From: Sarah Burrow <Sarah.Burrow@arun.gov.uk>
Sent: 08 June 2021 15:01
To: Planning.Responses <Planning.Responses@arun.gov.uk>
Cc: Simon Davis <Simon.Davis@arun.gov.uk>
Subject: RE: Planning Consultation on: BR/124/21/OUT

Engineers Comments Regarding Surface Water Drainage

Application No: BR/124/21/OUT

Site Address: To rear of 94 - 100 Hook Lane Bognor Regis PO22 8AT

Drawn by: gujskew	
Title: 295114_94 to 100 Hook Lane	
Date: 30/05/2018

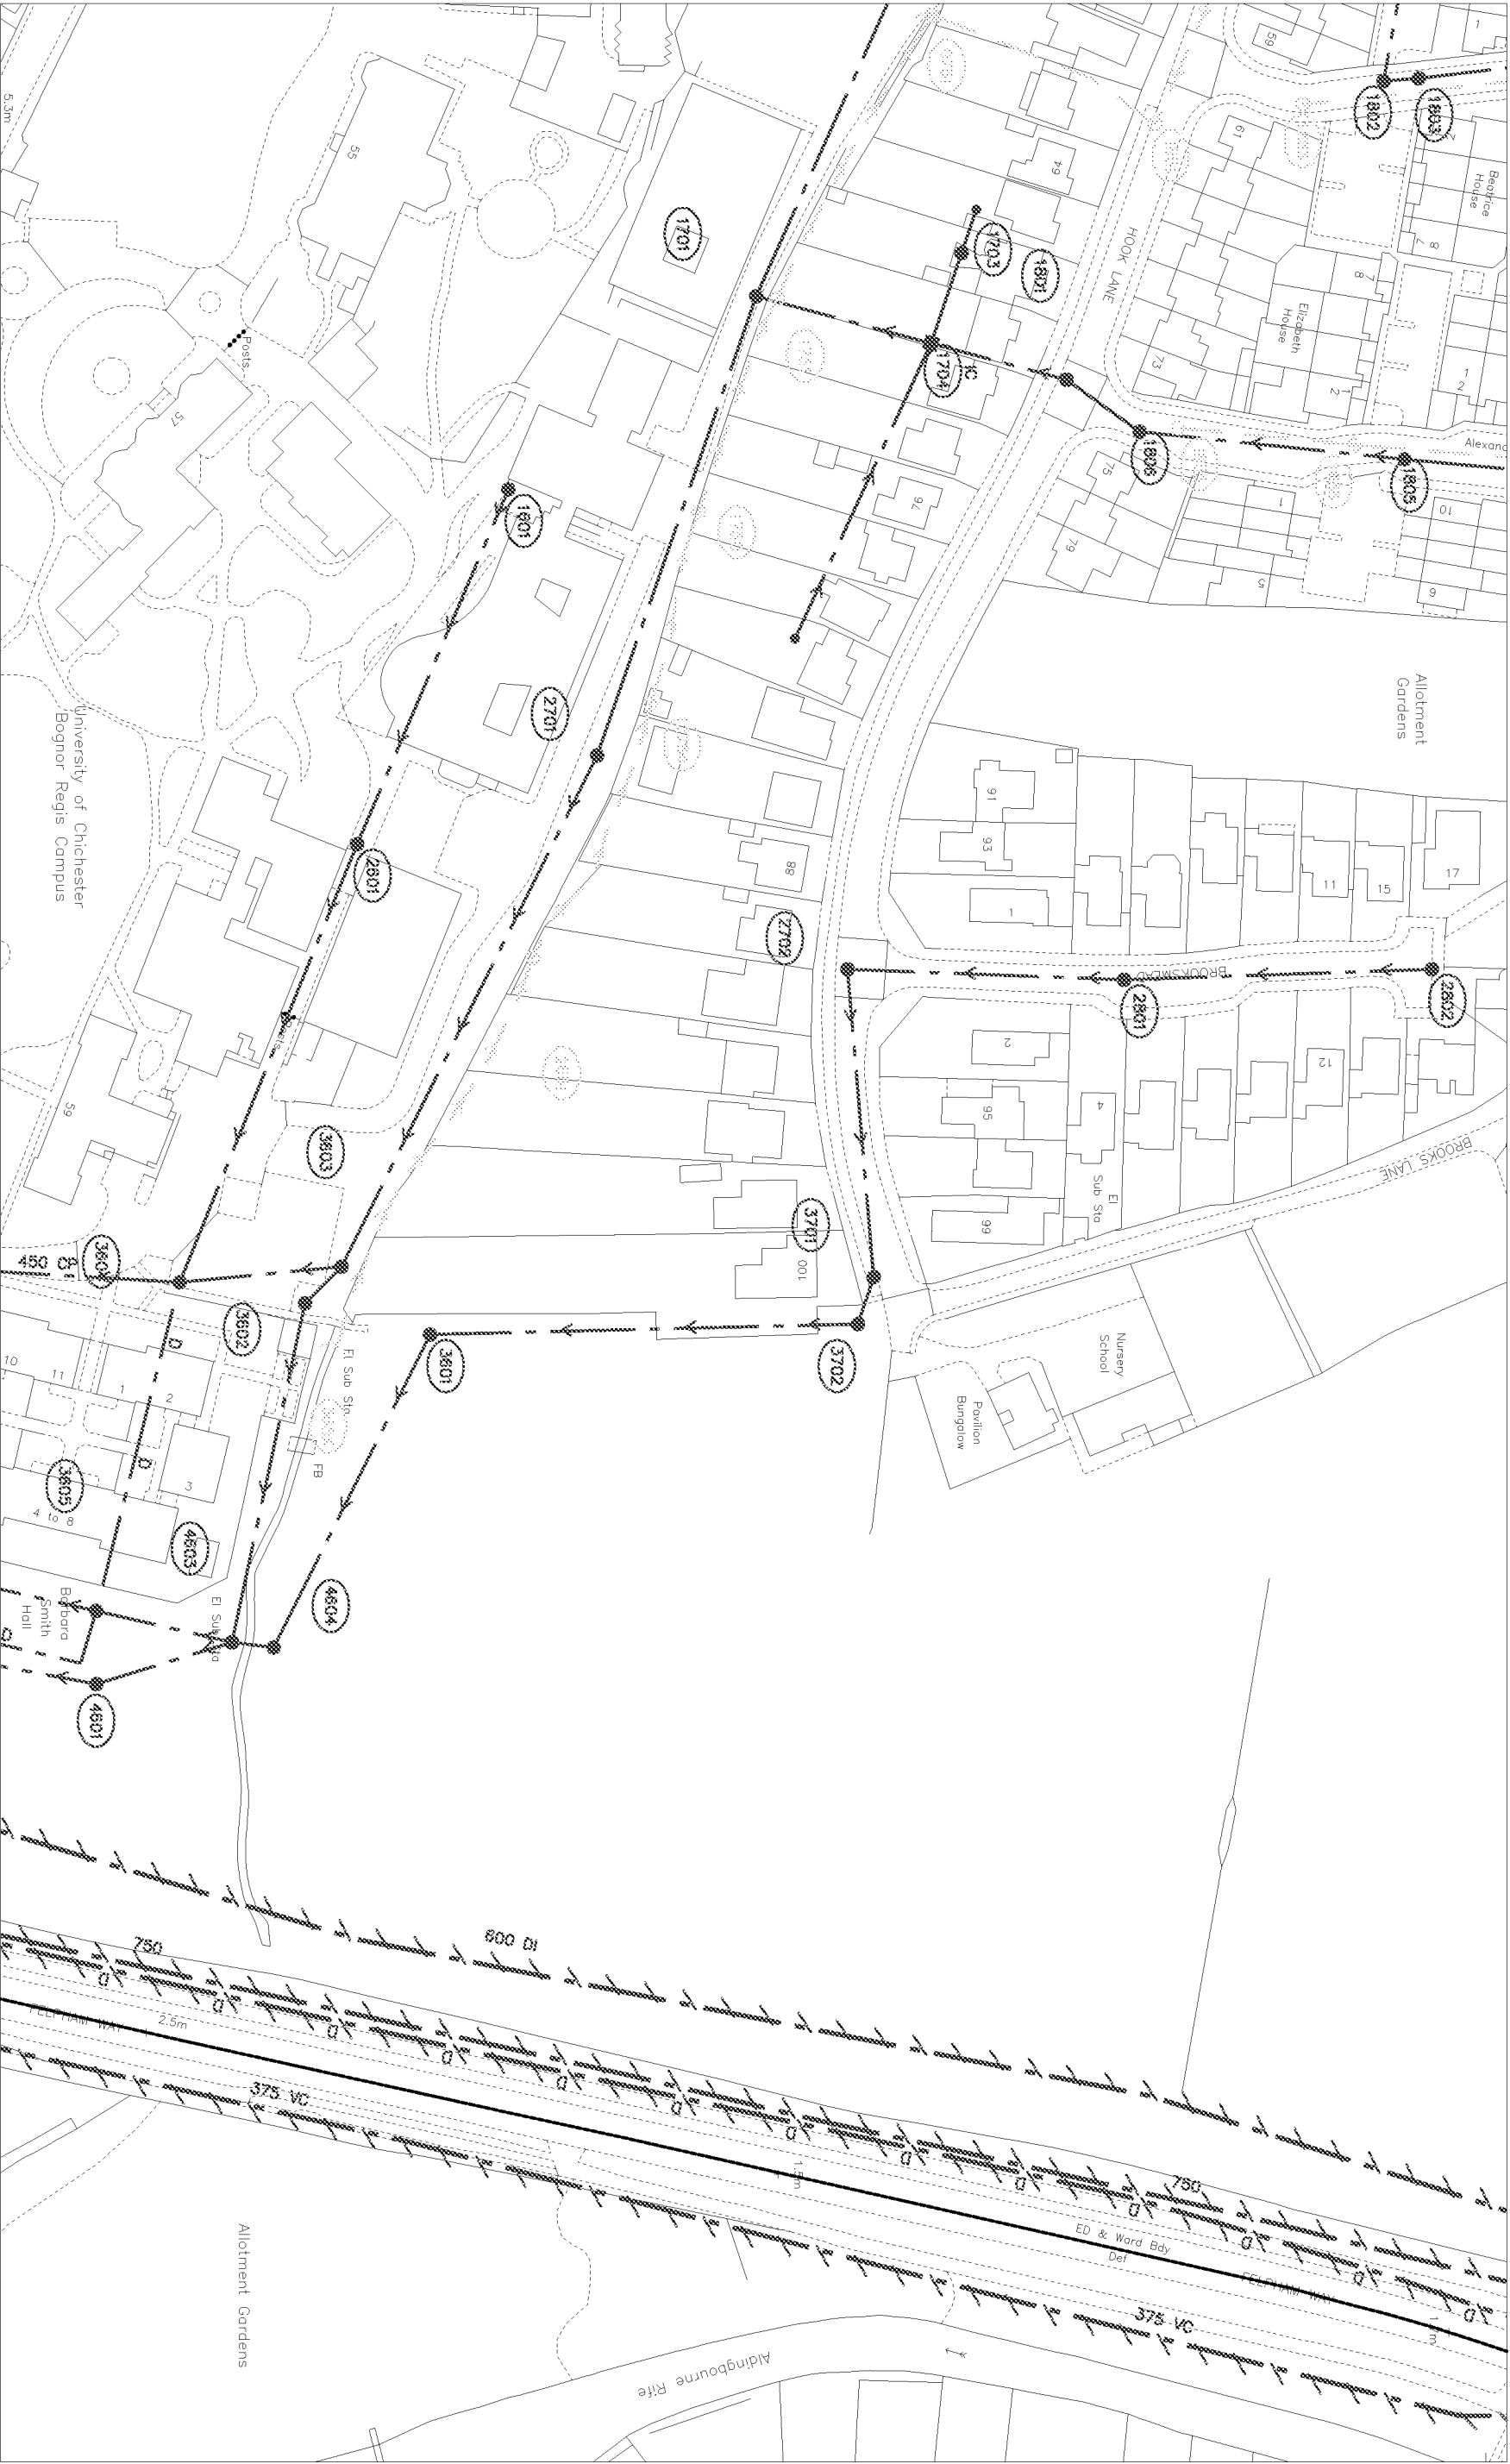
A Southern Water public surface water sewer (as shown on the current Southern Water records) runs through the south of the site on the line of the former watercourse. Please consult Southern Water regarding the necessary easements from this sewer. Any proposed connection will also require their approval.

FLOOD COMPENSATION AREA

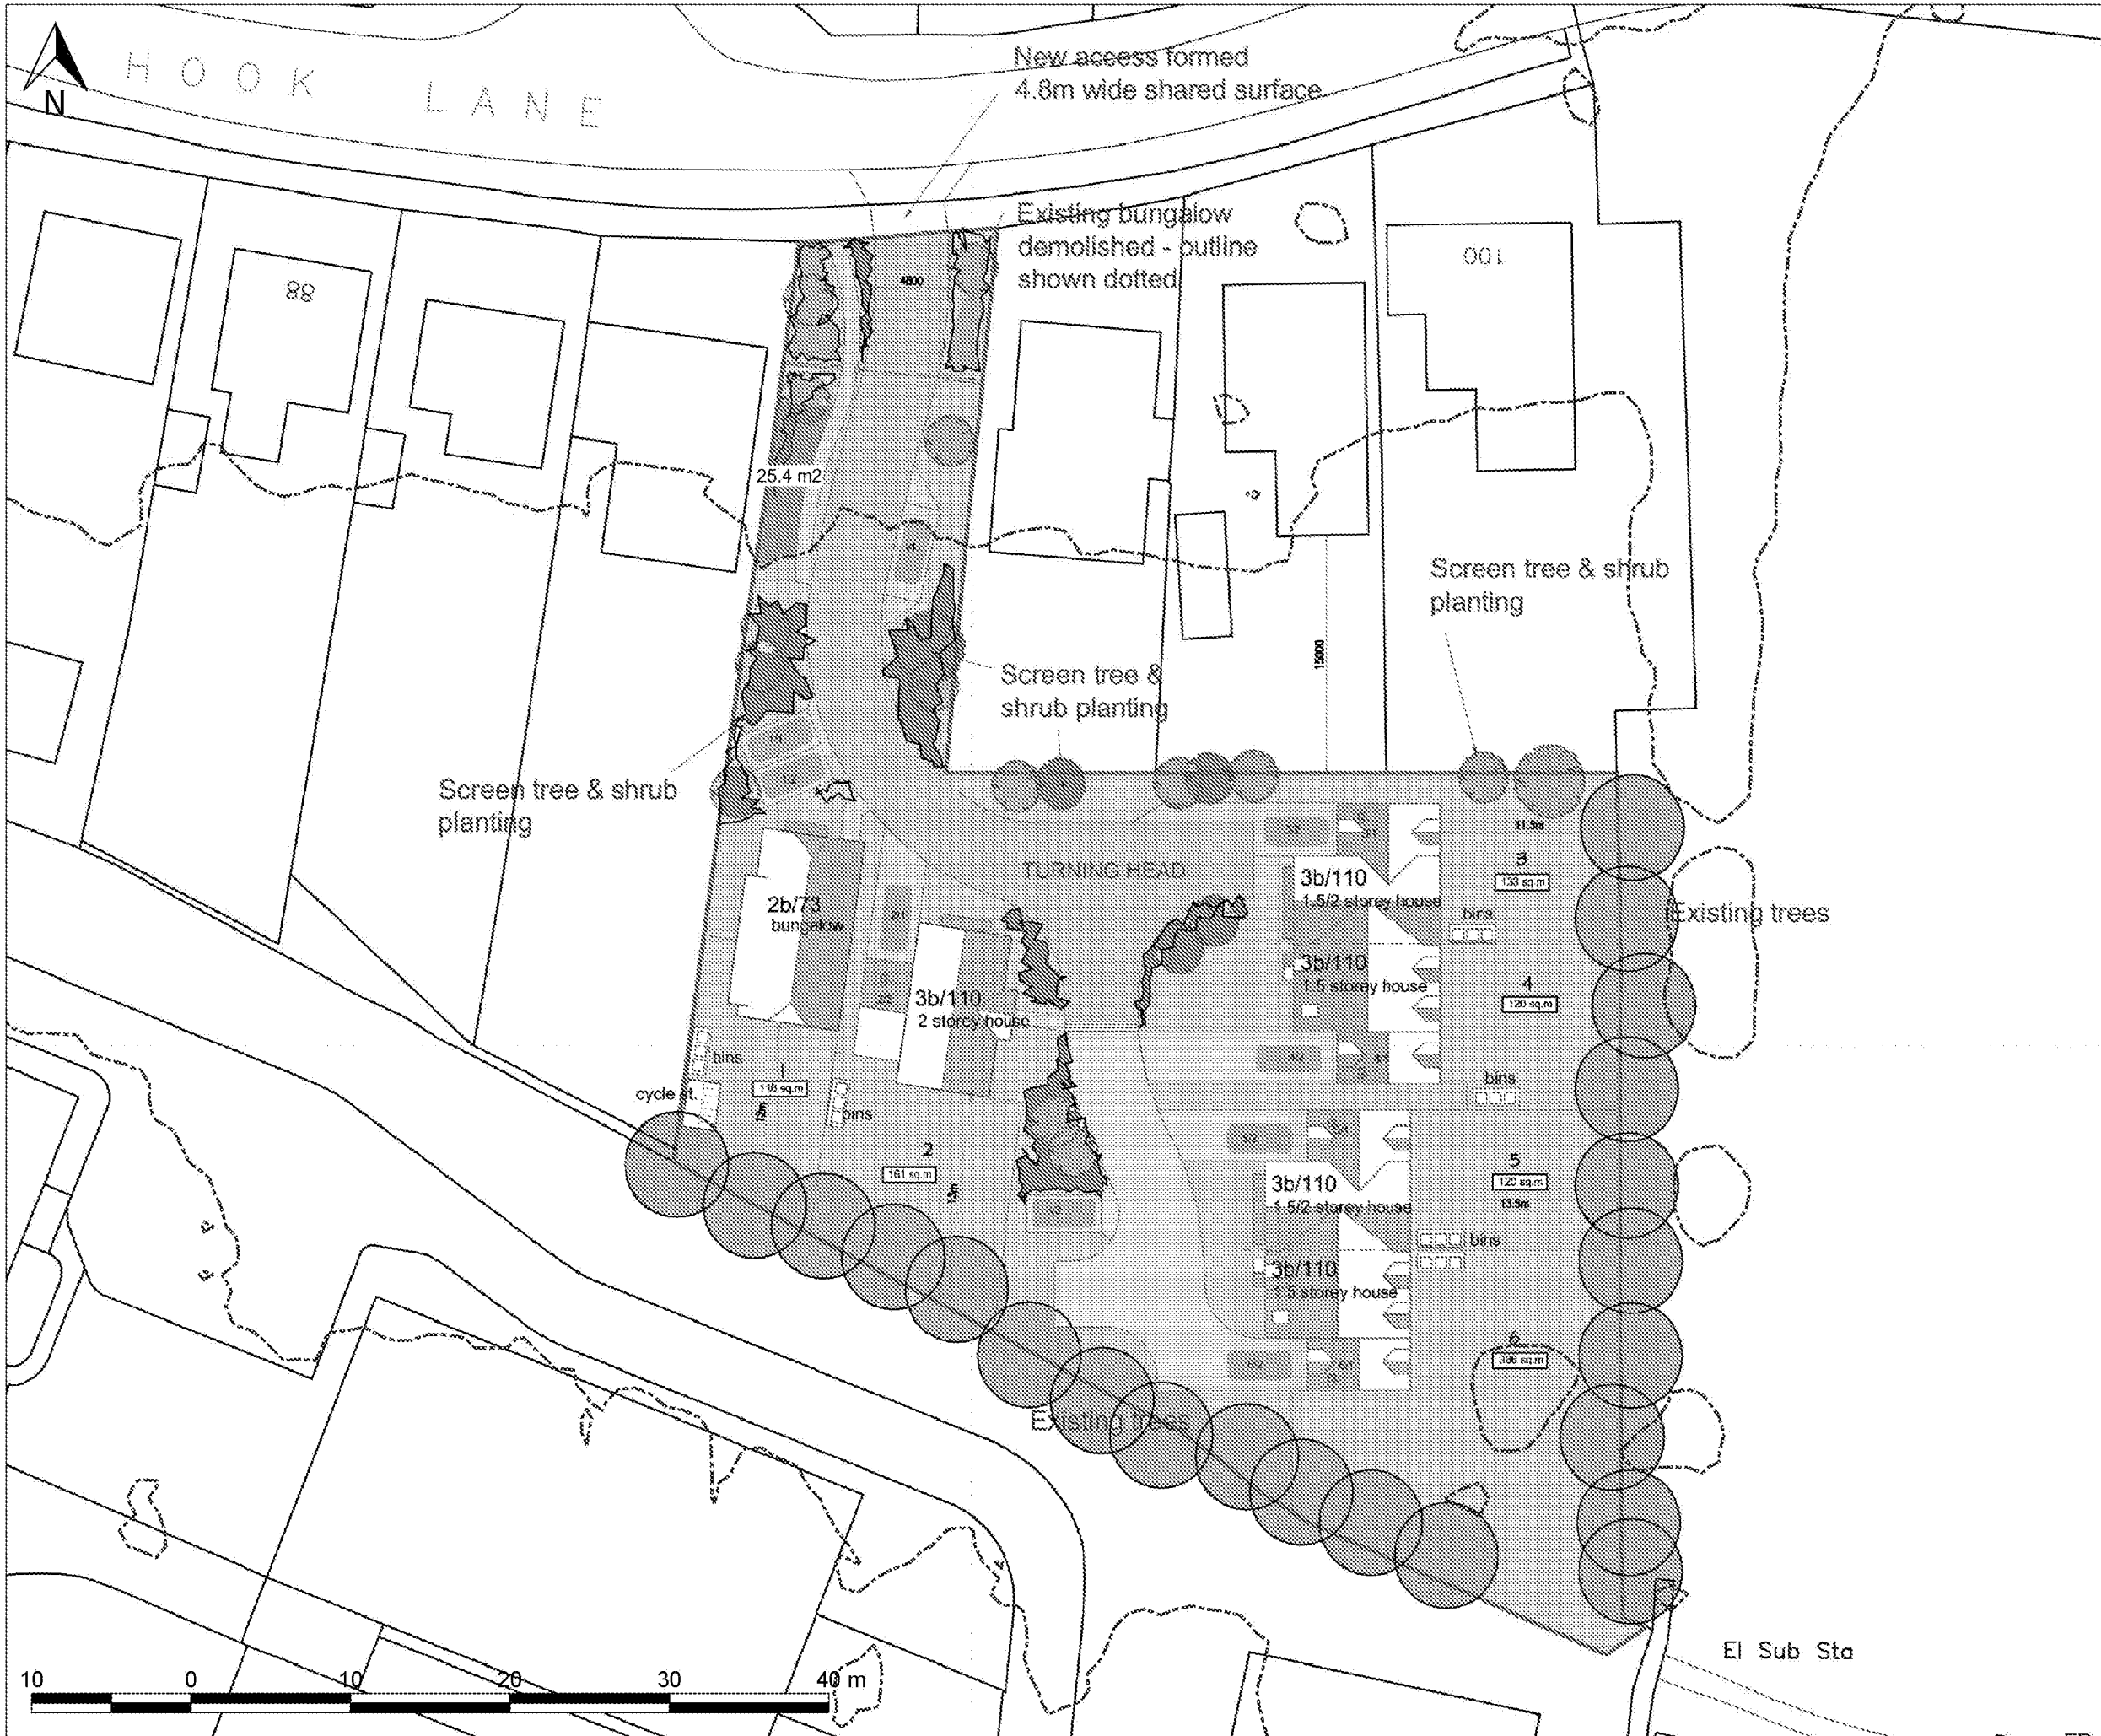
Any compensation to be provided, for the displacement of water within the fluvial flood plain will need to be agreed with the Environment Agency.

Areas of the site are also at risk of surface water flooding as shown on current mapping. This will also need to be considered as part of any overall flood compensation scheme, to ensure no increased risk of flooding as a result of the development.
